DRB CASE ACTION LOG - BLUE SHEET

Project #: 1009945 Application #: 14DRB-70124  
 Project Name: Lands Of ~~John~~ Josh Romer  
 Agent: The Survey Office Phone #:

**CITY OF ALBUQUERQUE  
PLANNING DEPARTMENT  
May 7, 2014  
DRB Comments**

**RE: Tracts 127 & 130 MRGCD Map #35**

**PLAT OF
LOTS A & B
LANDS OF JOSH ROMERO
PROJECTED SECTION 12, T. 10 N., R. 2 E., N.M.P.M.
ALBUQUERQUE GRANT
CITY OF ALBUQUERQUE
BERNALILLO COUNTY, NEW MEXICO
APRIL 2014
SHEET 2 OF 2**

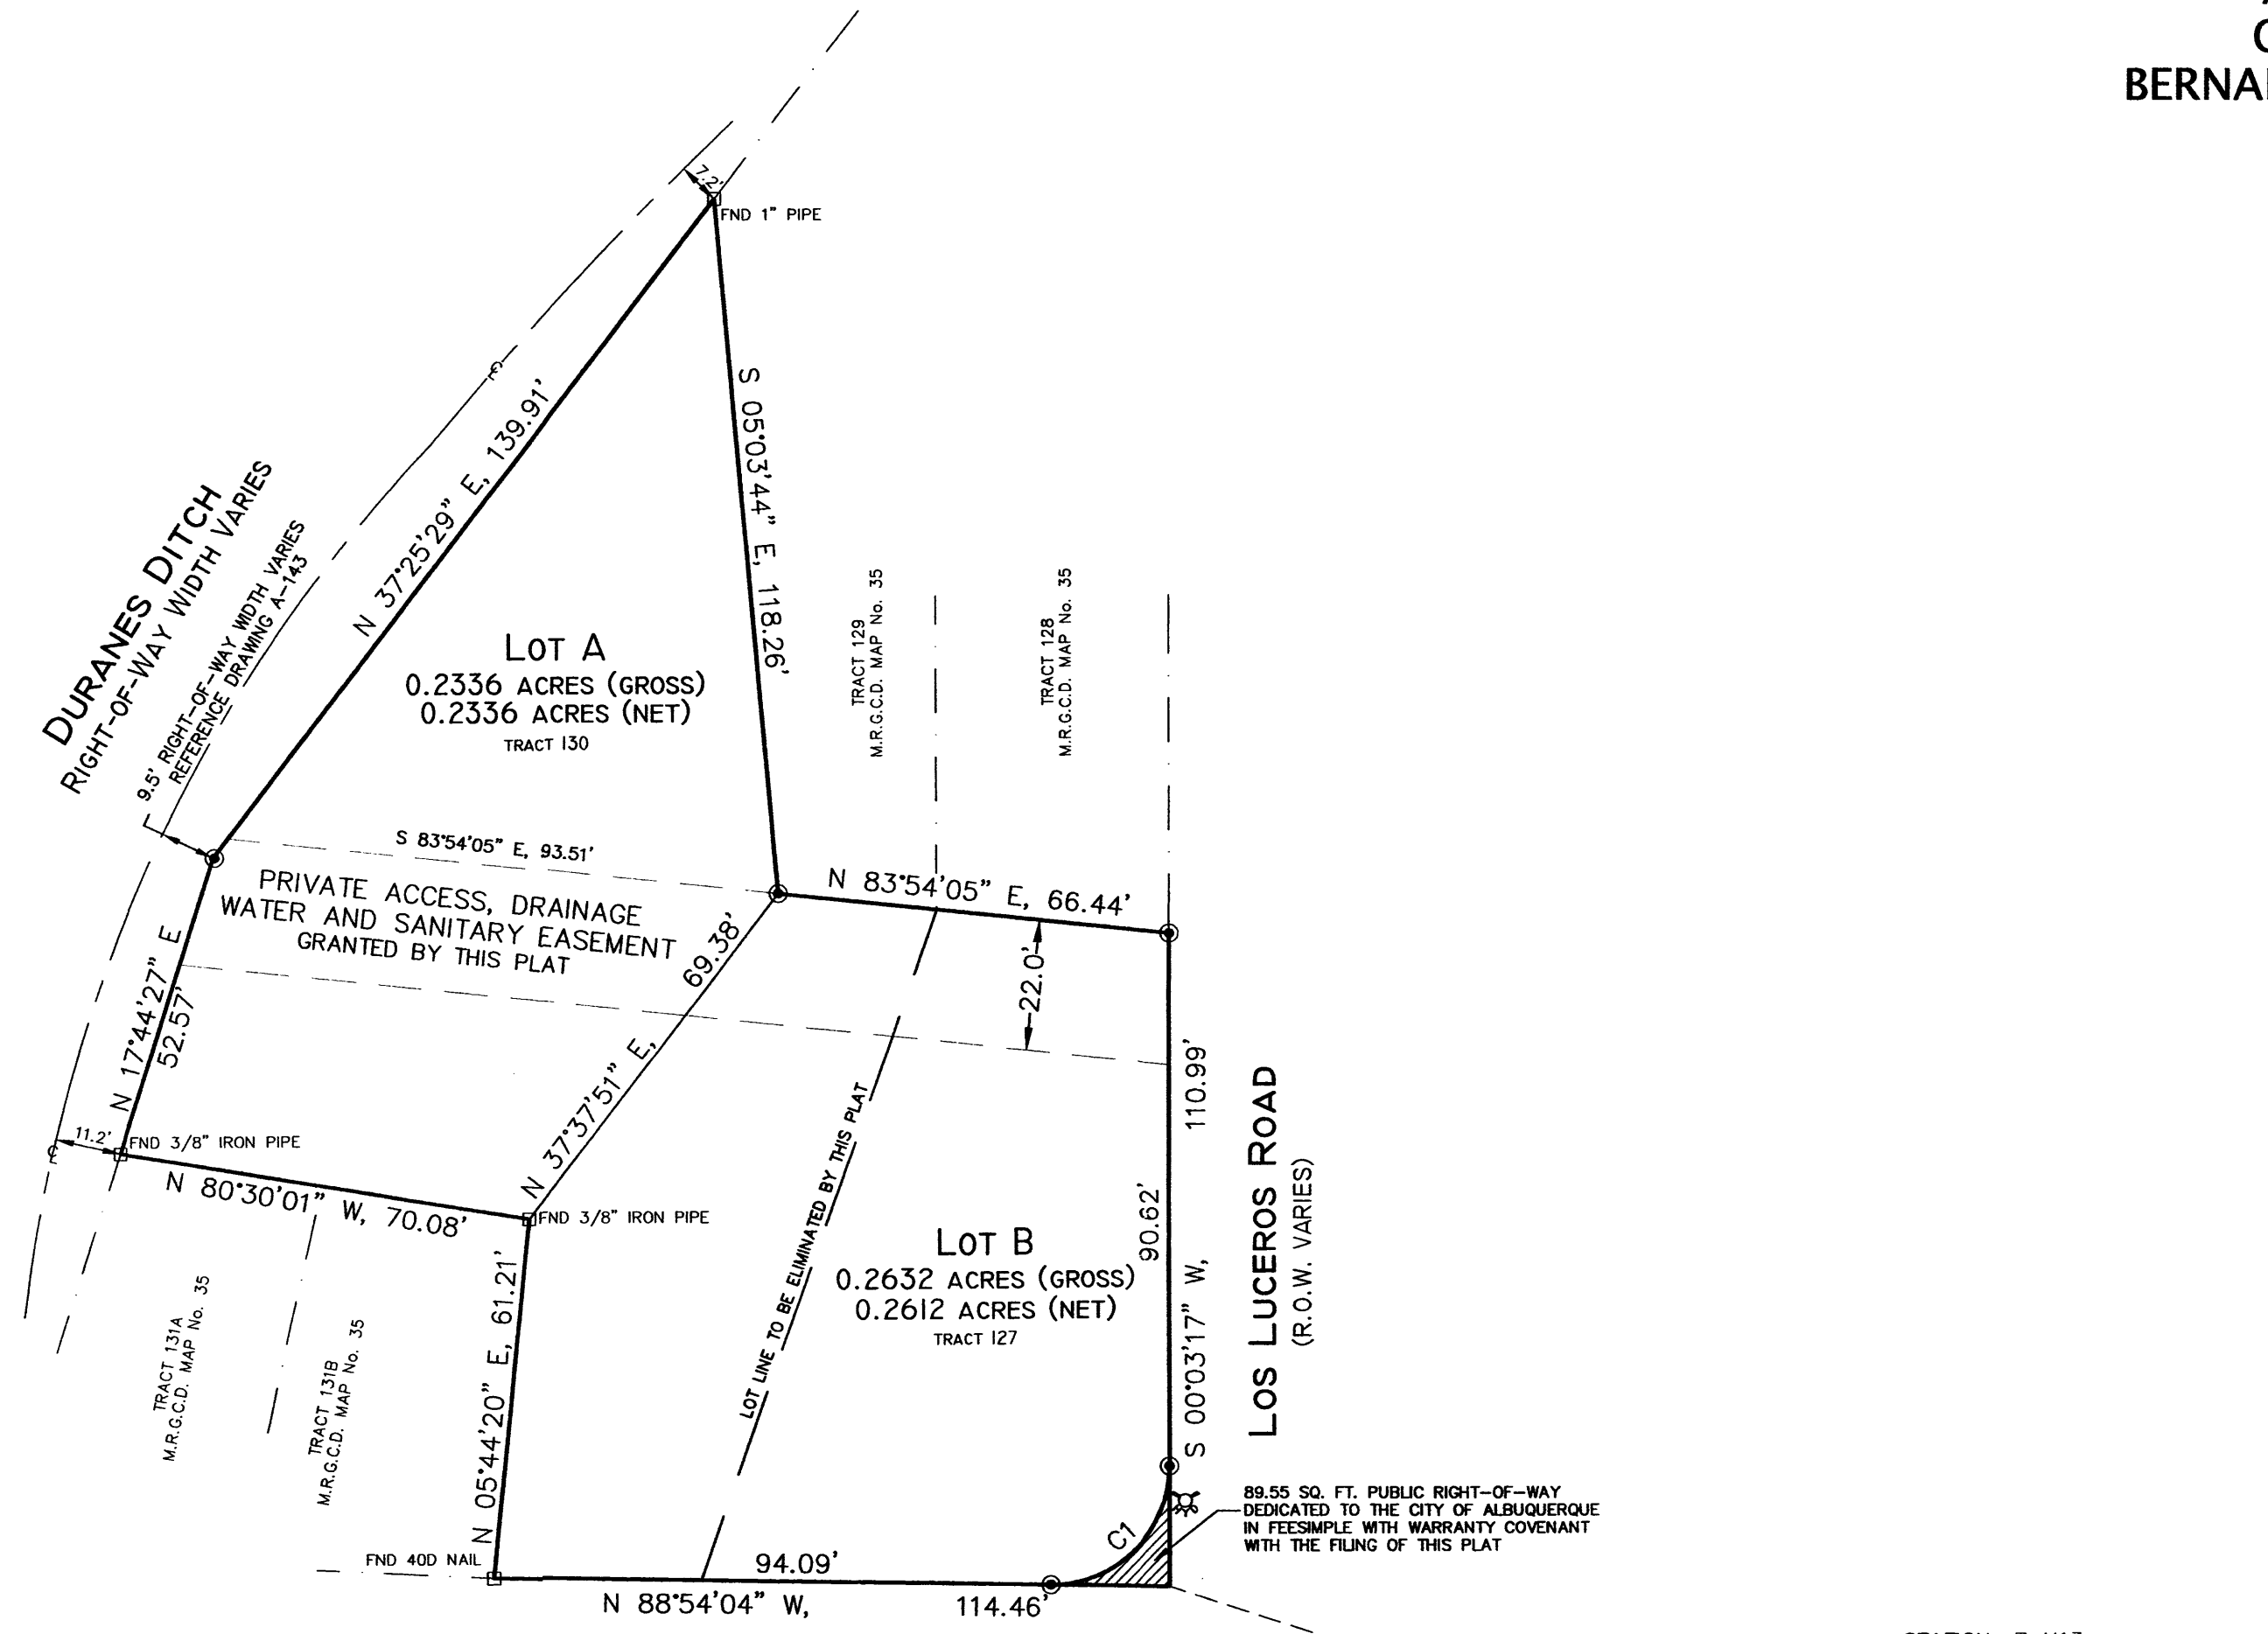
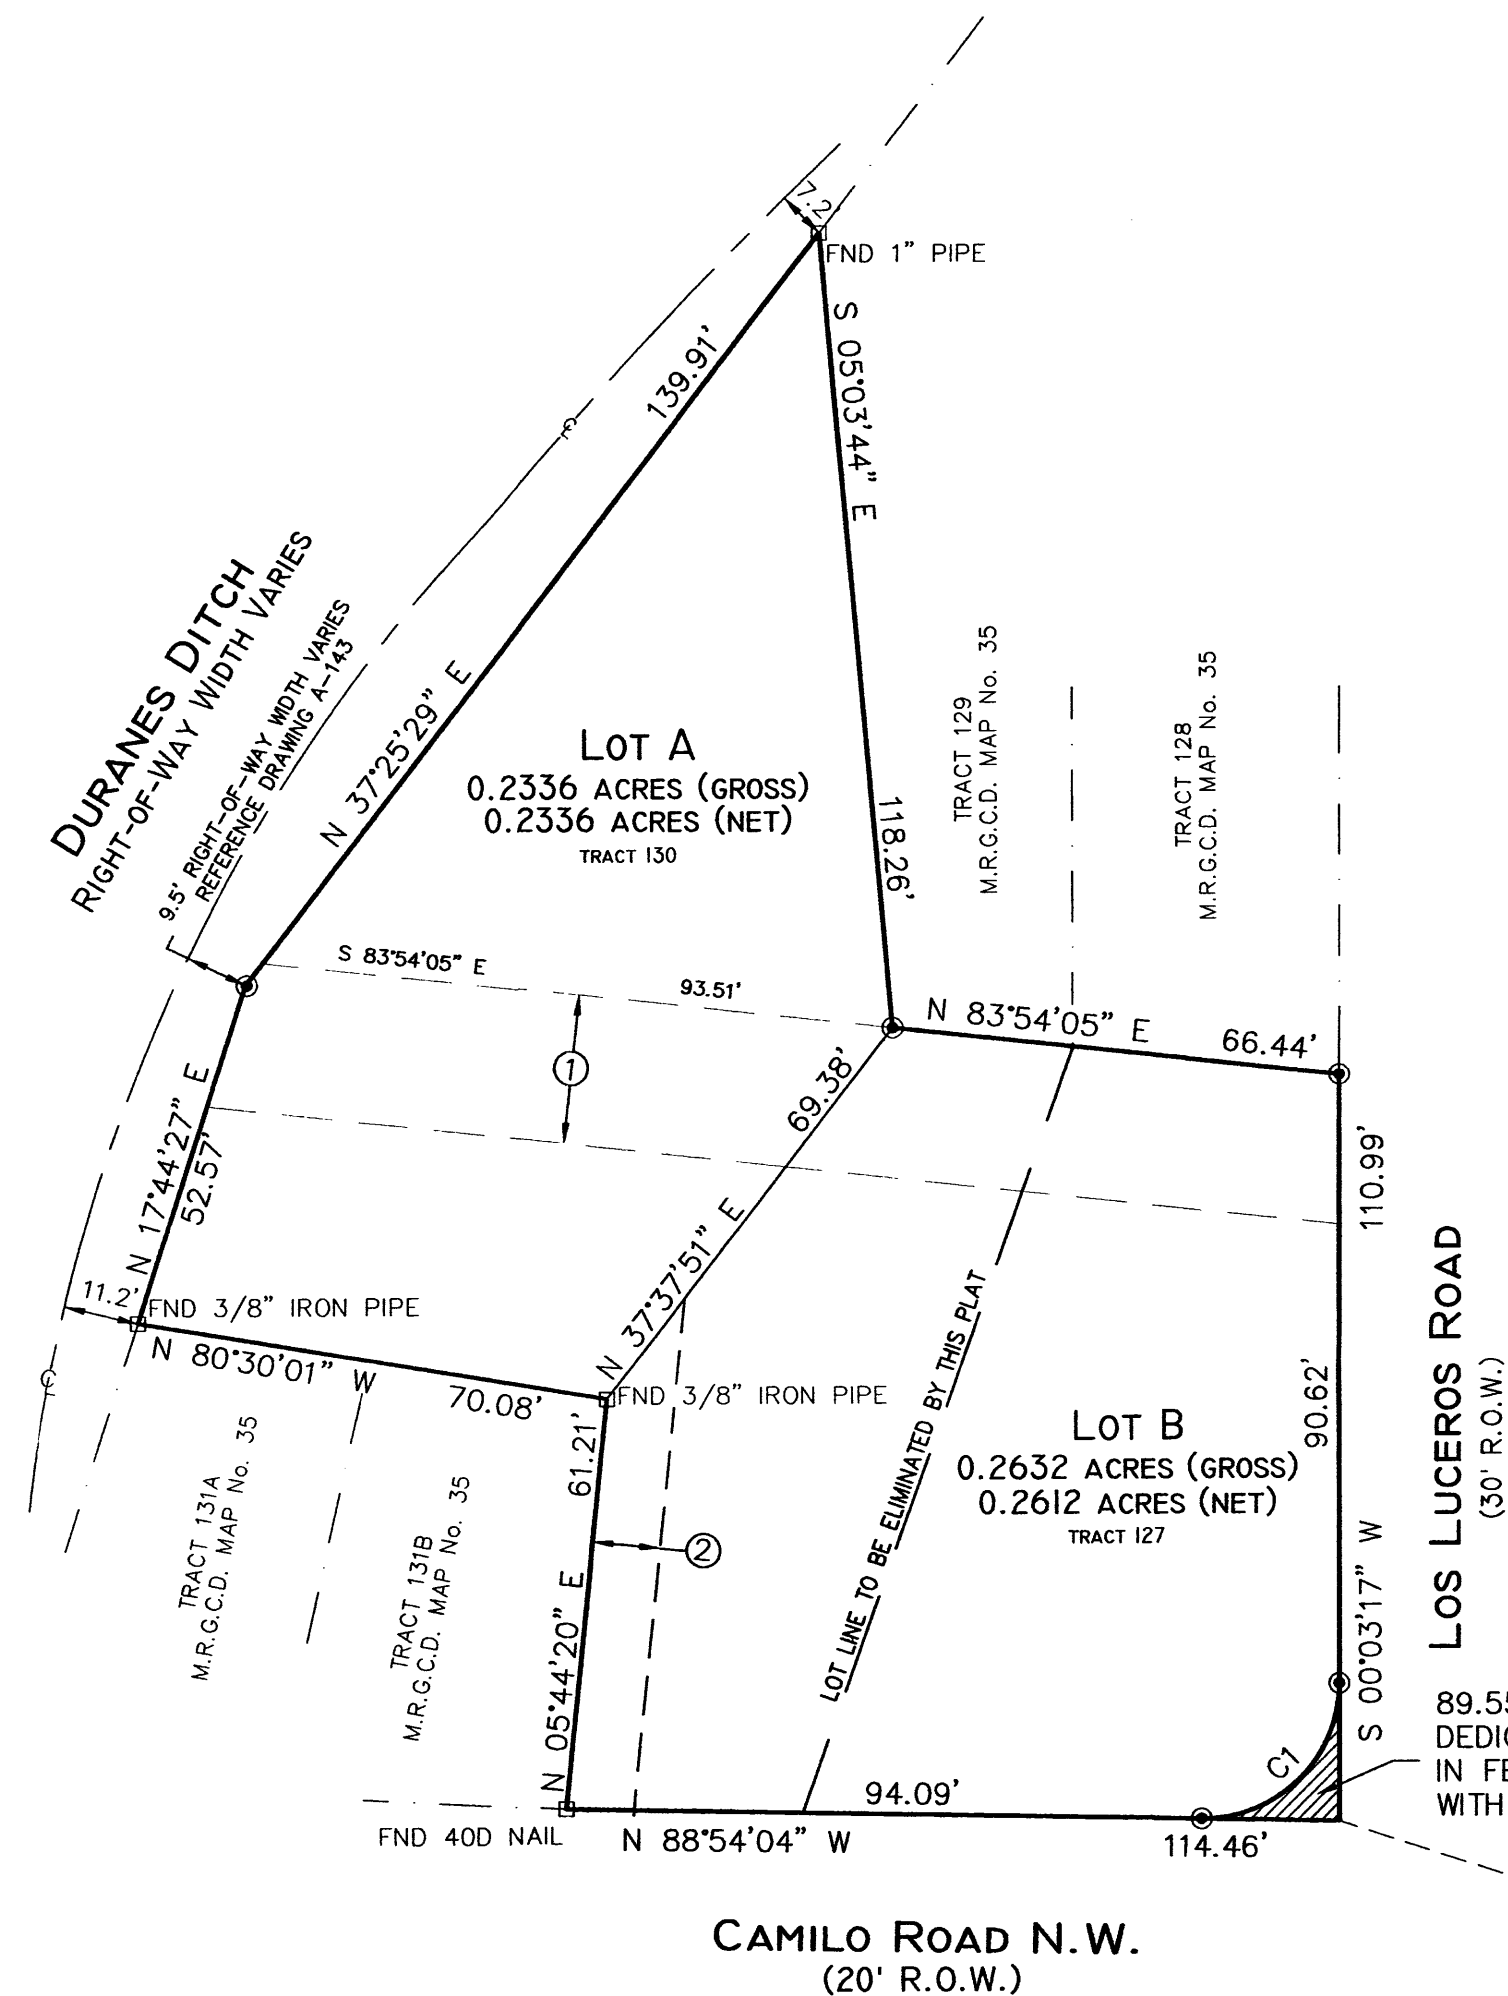
PLANNING (Last to sign): drb utility signatures

owner's acknowledgment of new E'ment

Per Sketch Plat comments, it needs to be demonstrated that the proposed rear lot is buildable with a 22 foot easement running through the middle –Zoning Enforcement needs to verify required setbacks and how large a building footprint is possible on a site sketch. Maintenance and beneficiaries of easement(s) need to be called out on plat.
